From: Martyn White
Sent: 19 July 2019 14:52
To: Planning.Responses <Planning.Responses@arun.gov.uk>
Cc: Amber Willard <Amber.Willard@arun.gov.uk>
Subject: BR/184/19/L

BR/184/19/L

The proposal affects the Bognor Regis pier which is a Grade II listed building. The pier is also located within the Bognor Regis (The Steyne and Waterloo Square).

38cm
Blue
Aluminium
Composite
Circle

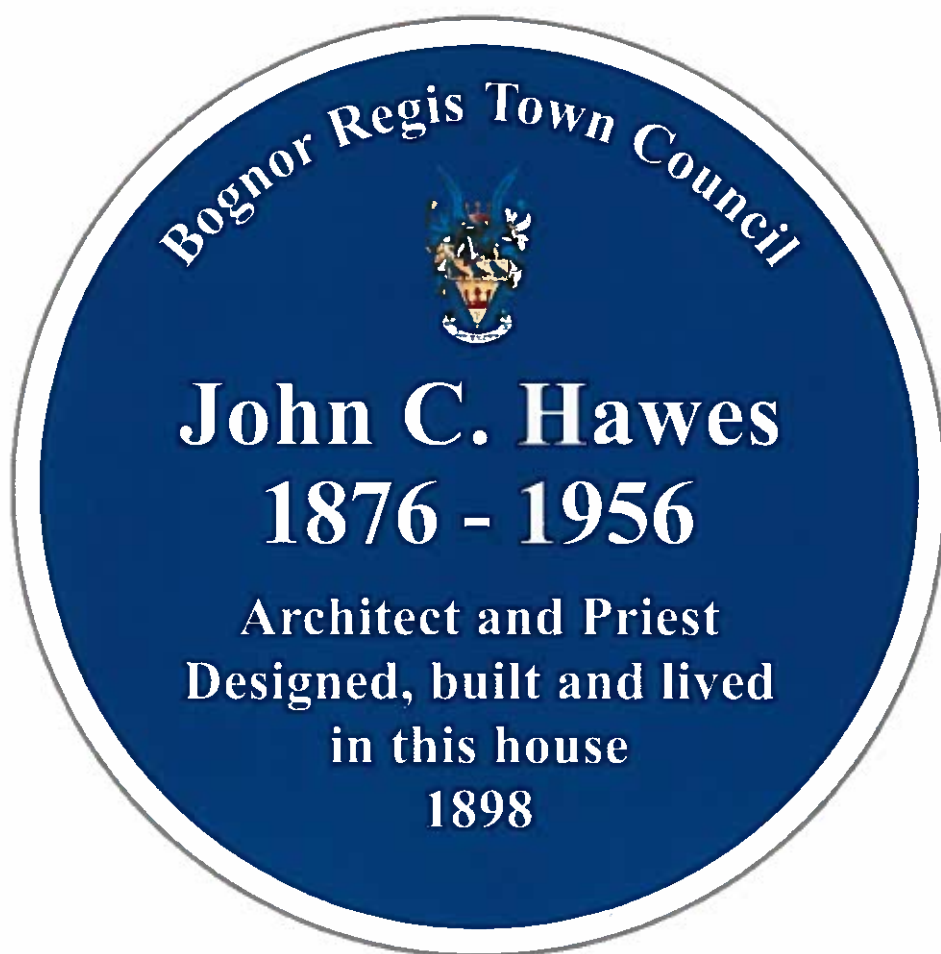
The proposal is to place a 'blue plaque' on the side elevation to commemorate a local resident. The plaque is circular in appearance and measures only 38 cm across. As such it will not be significantly visible on the building, or to the conservation area.

However, whilst the concept of placing the plaque on this elevation is acceptable, it is not clear where the exact location will be. Is it possible to have this information confirmed, so that a more detailed assessment may be undertaken?
